February 1, 2019

**Subject: Alameda / San Pedro Development Traffic Impact Study
Southeast corner of Alameda and San Pedro
Albuquerque, Bernalillo County, New Mexico**

This letter is to inform you that the **FINAL** Traffic Impact Study (TIS) for the proposed Alameda / San Pedro Development at the southeast corner of Alameda and San Pedro dated January 23, 2019 has been reviewed.

Overall Site Plan

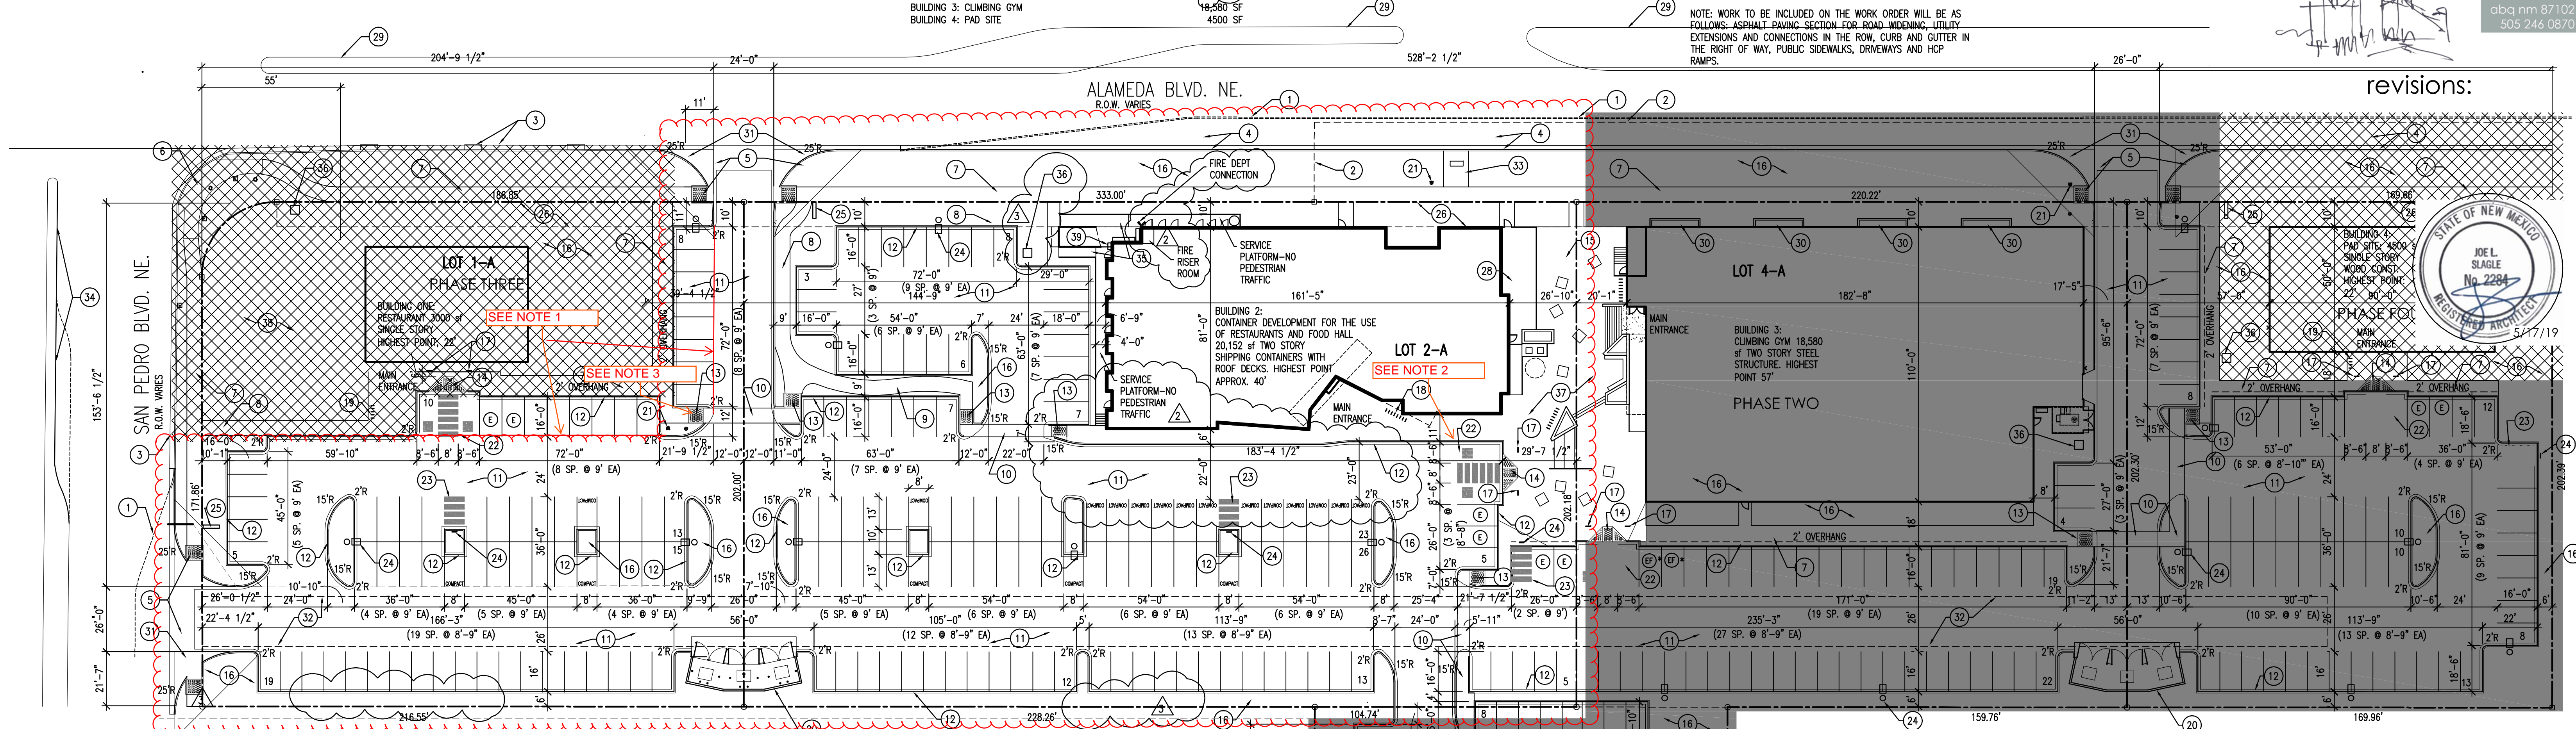
The NMDOT has no objection to the (2) partial Right In/Out only access points on Alameda eastbound located approximately 265 feet and 820 feet east of the signalized intersection of Alameda and San Pedro, east of I-25. See Exhibit A for the conceptual site plan.

1. The development shall provide pedestrian connectivity along the frontage of its property and update the ADA curb ramps as needed on Alameda.
